Re: Serenity Amenity

This department is reviewing the plan you submitted for the Serenity Amenity swimming pool to be constructed at 325 Streamside Terrace, Fuquay Varina. This plan review is being conducted in accordance with the current North Carolina Rules Governing Public Swimming Pools (15A NCAC 18A .2500).

SP-2

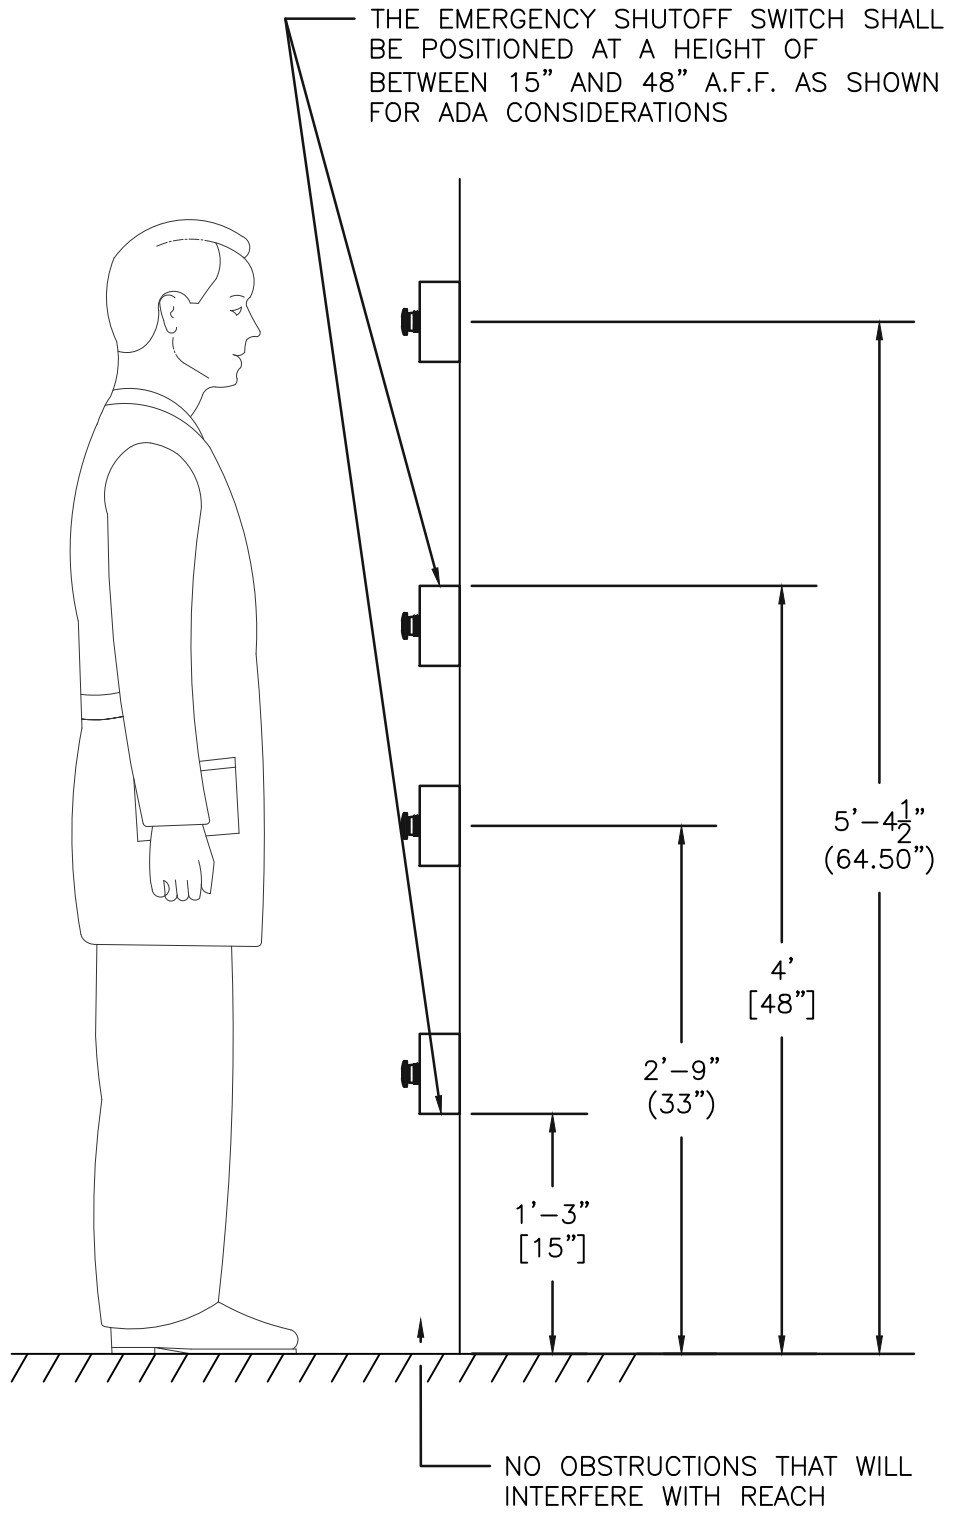
-One unit of life saving equipment is specified on plans. Any pool in excess of 3000 square feet of total surface area requires 2 units of lifesaving equipment to be provided.

RESPONSE: Another set of lifesaving equipment has been added to make 2 units of lifesaving equipment.
